KITTITAS COUNTY FIRE MARSHAL'S OFFICE

May 16, 2016

Re: Bare (BL-16-00005)

NELSON SURVEYING
PROFESSIONAL LAND SURVEYING
707 S. TAMARACK STREET
ELLENSBURG, WA 98926 (509) 9290181
BARE PROPERTY

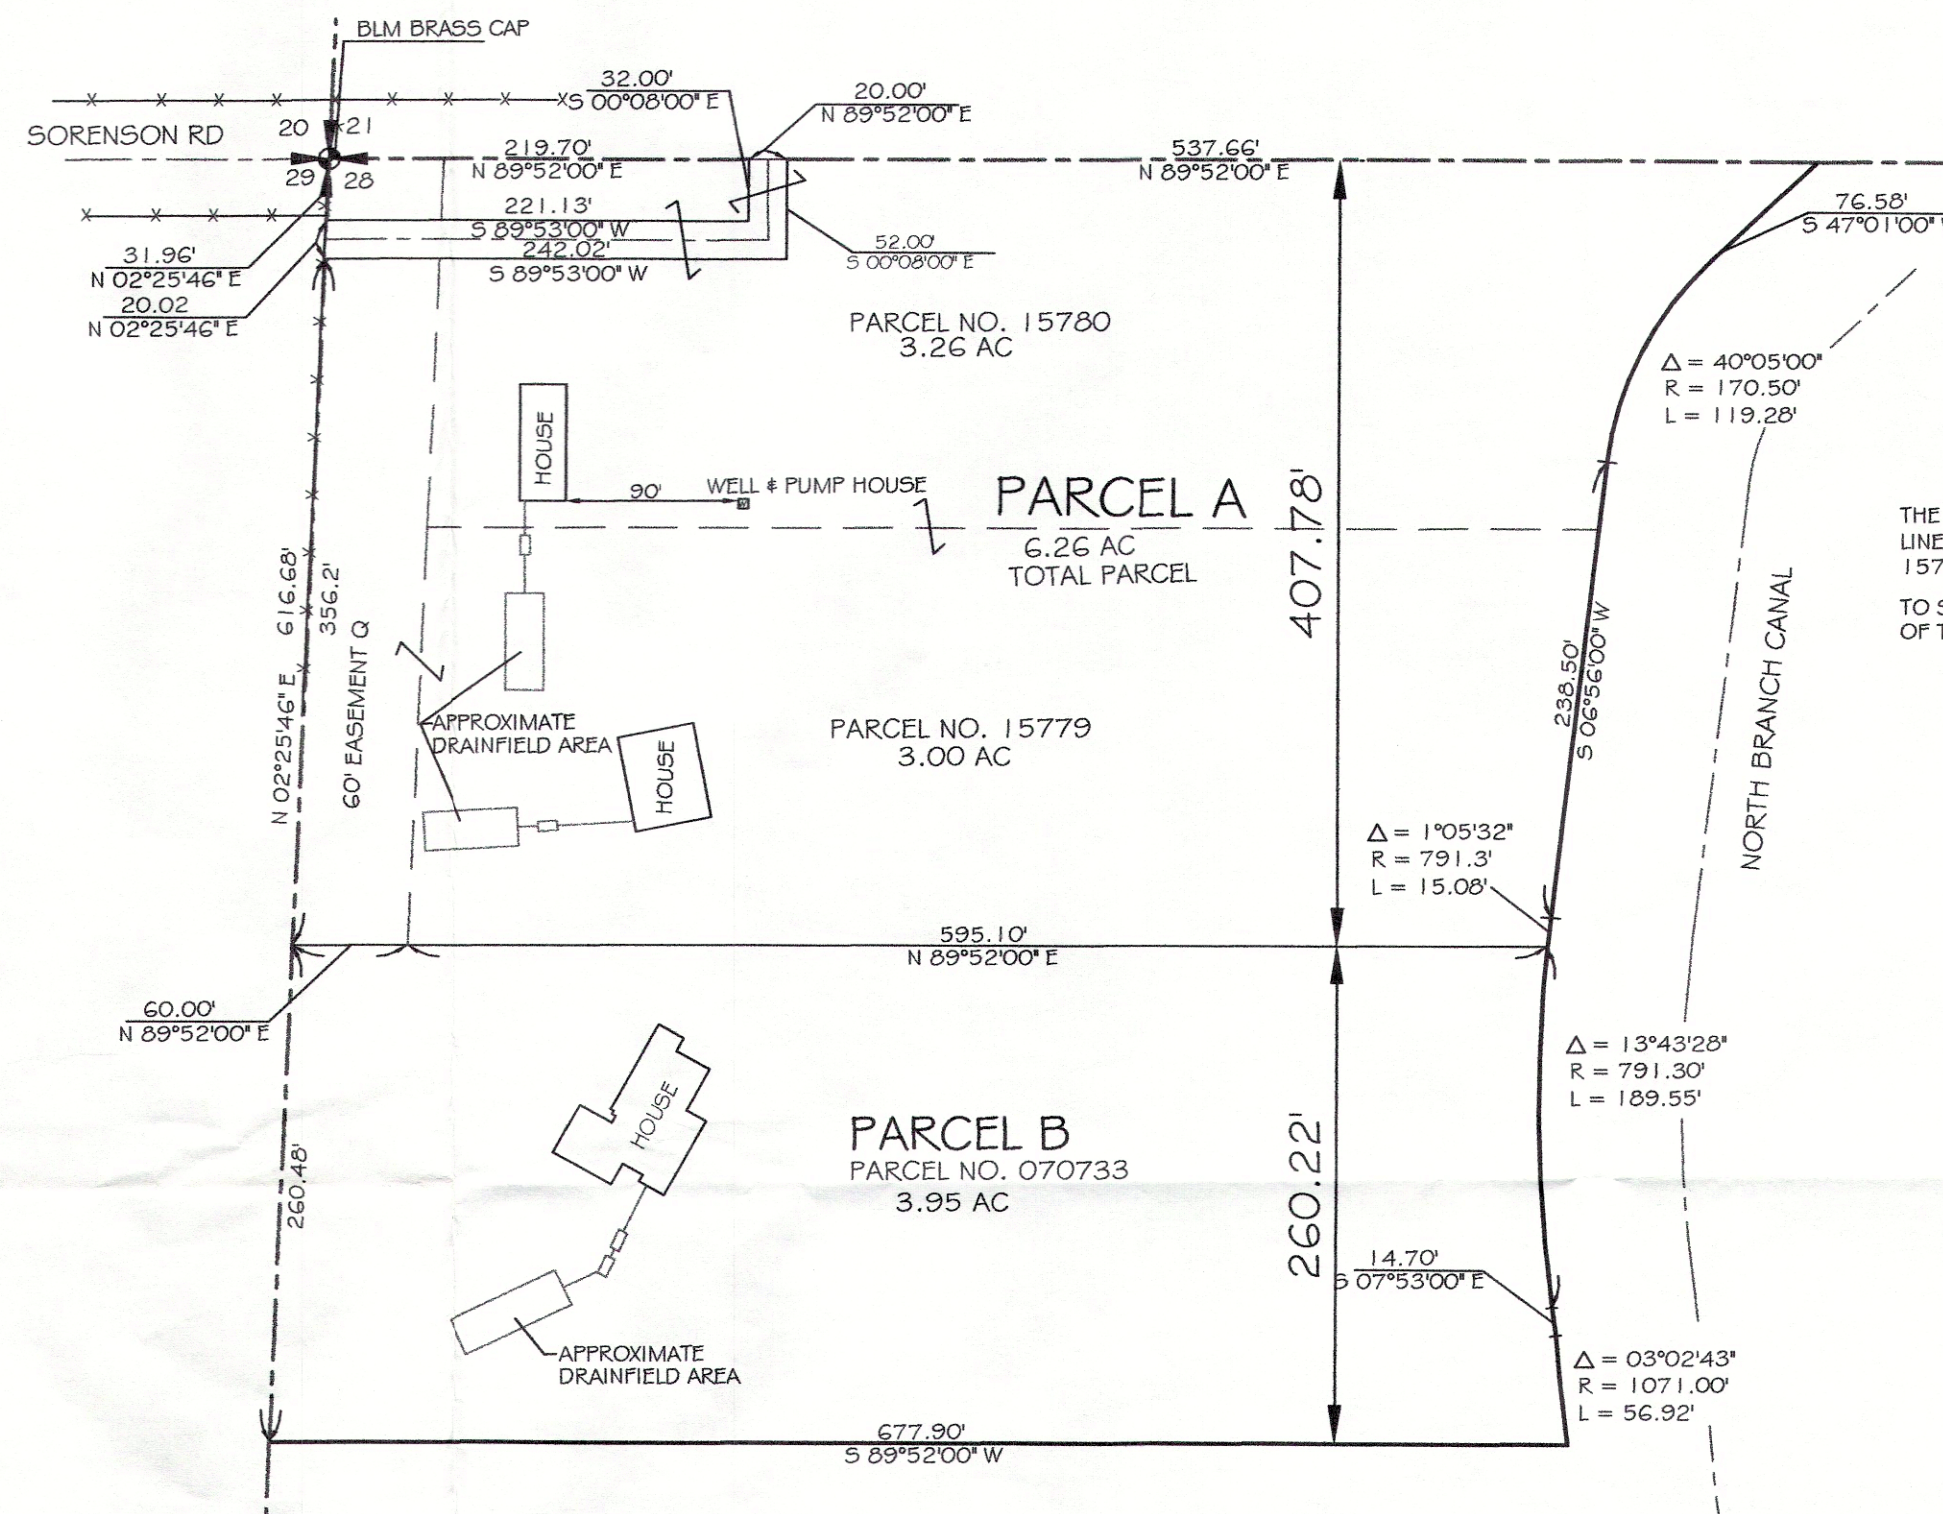
- Ensure that boundary line adjustments do not infringe upon existing structures, to include propane tanks, etc.
- Ensure adequate access for fire apparatus. Any driveways or access points created based off the new lot configurations shall comply with Kittitas County Code 20.02.030.
- All future development must comply with the International Fire Code.
